# Charlotte Department of Transportation

## Memorandum

**Subject:** Rezoning Petition 08-050: Located on the north side of Charles Avenue  
between Yadkin Avenue and North  
McDowell Street

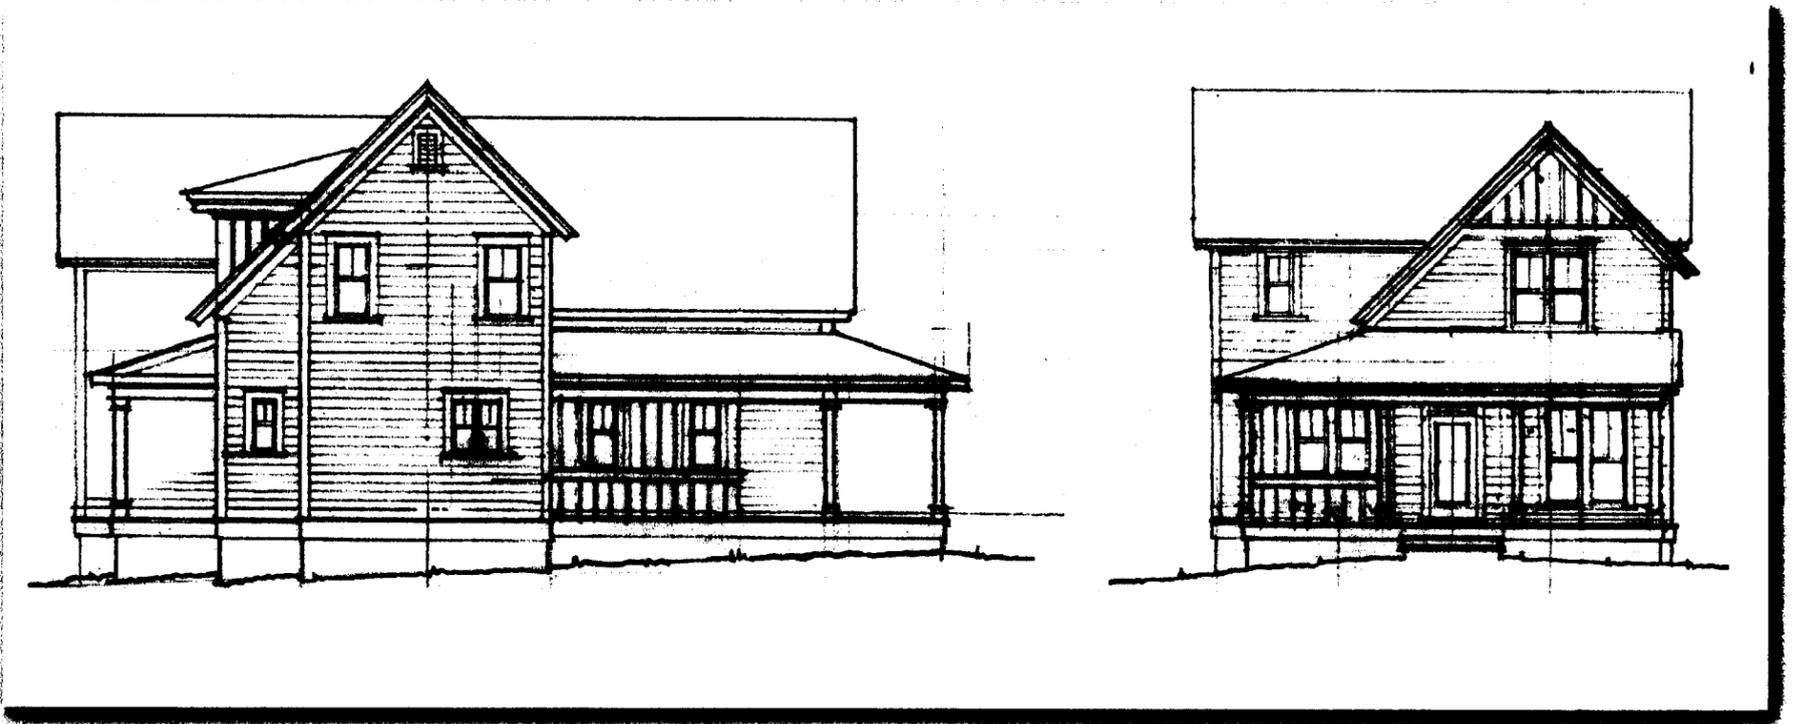
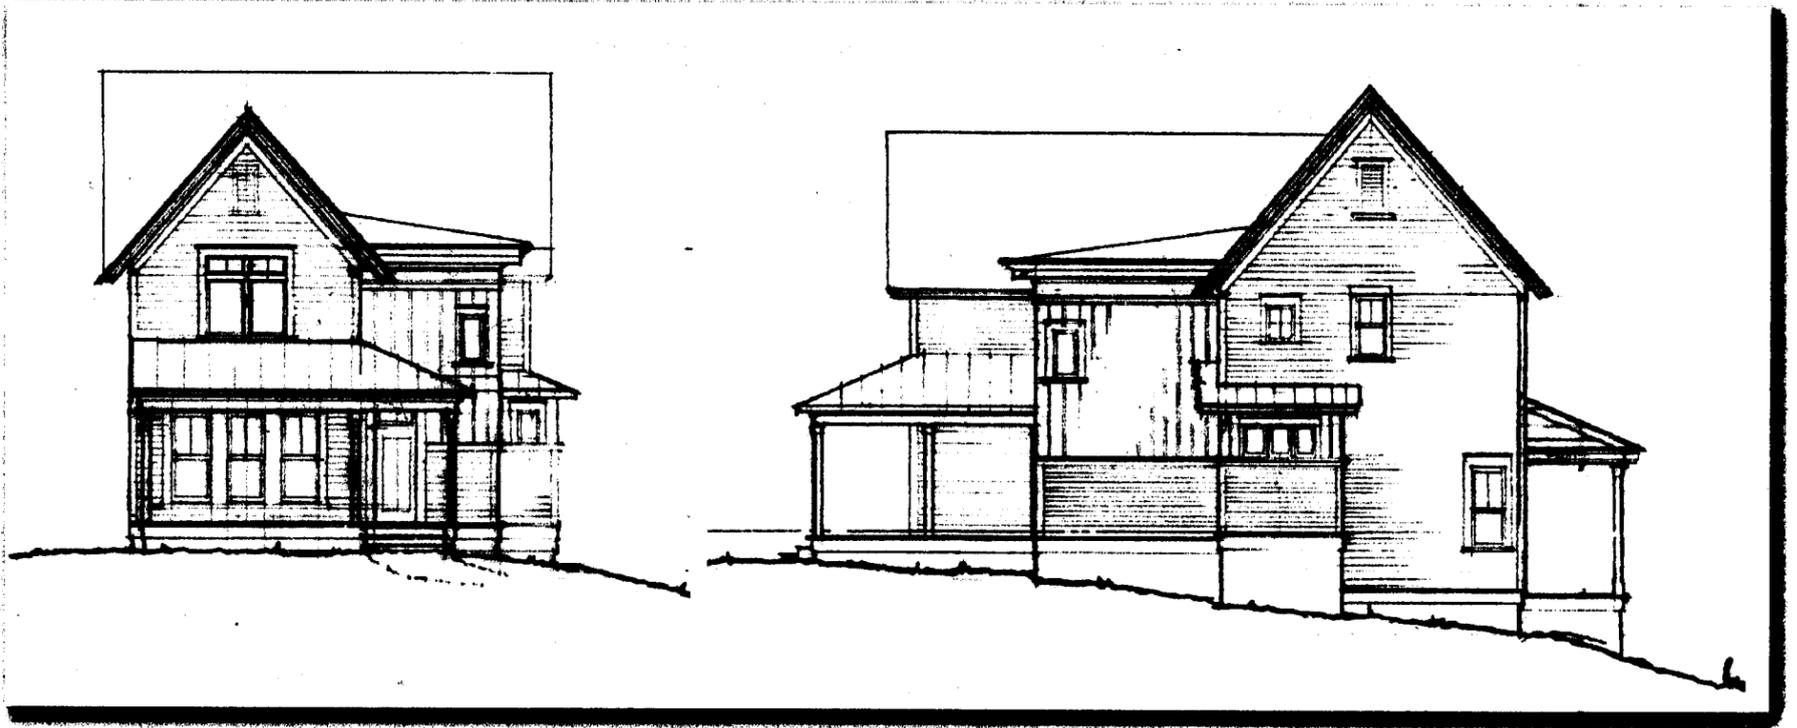
1. The plan needs to show proposed building locations, driveways, and parking areas (garages, alleys, pads, etc.). There is insufficient information to determine how this site would be parked or if the commitment of providing two off-street parking spaces per unit can be met. Use of shared or paired driveways or a rear alley is strongly encouraged.
2. To meet the requirements of the UR-1 District, the developer must remove the existing monolithic curb and sidewalk on Charles Avenue and construct an 8-foot planting strip and a 6-foot sidewalk.
3. In conformance with the adopted Urban Street Design Guidelines, Charles Avenue needs to be designed as a Local Residential Street-Medium (27' back-of-curb to back-of-curb, or 13.5'

from the centerline of the street to the back-of-curb). The location of the new curbline is dependent on the parking that can be provided for each unit on-site (see comment 1). If sufficient parking cannot be provided on-site, then on-street parking will be necessary and require additional street width.

4. CDOT can support the abandonment of the unopened or “paper” streets (Alexander and Myers Streets) conditioned on a 15-foot easement being provided between Myers Street and Charles Avenue for a pedestrian/bicycle connection. Depending on review/approval of a detailed cost estimate, CDOT may be able to assist in the funding of what we estimate to be approximately half of its cost. At this time we believe that this would include funding the bridge and the offsite work, if the developer funds the on-site work and does all of the construction. The connection would need to meet ADA requirements, be at least 10 feet in width, and be located within a 15-foot easement.
